**Town & Country Planning Act 1990 (as amended)
Town & Country Planning (Development Management Procedure) (England) Order 2010 (as amended) - Article 35
Application for Certificate of Lawfulness for a Proposed Use or Building**

Development Application for a Lawful Development Certificate for a proposed change from tile hanging to weatherboarding
Location 33 Seafeld Road Rustington

BACK OF PROPERTY

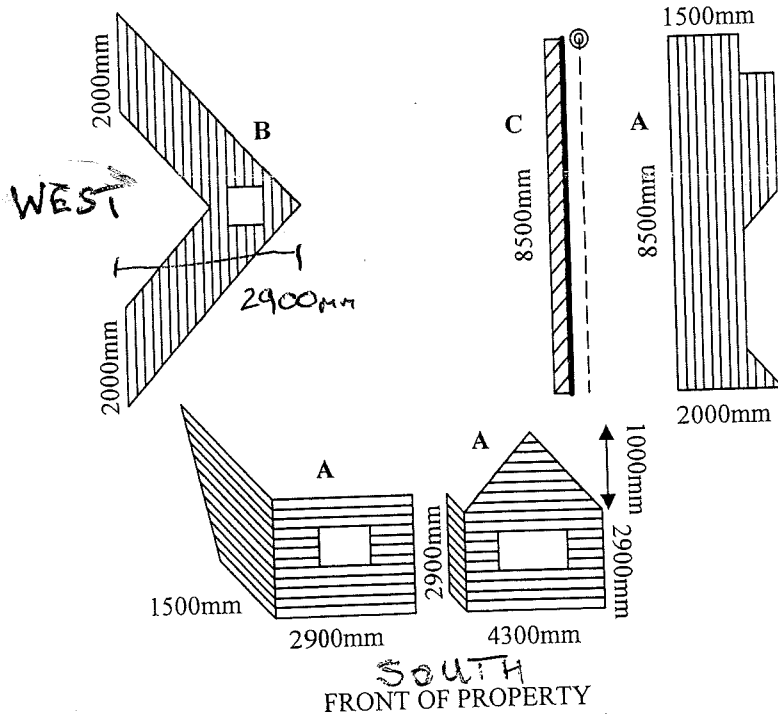
Please amend the Square Deal information you have submitted as we believe labelled the East and West the wrong way round. Please amend and return accordingly.
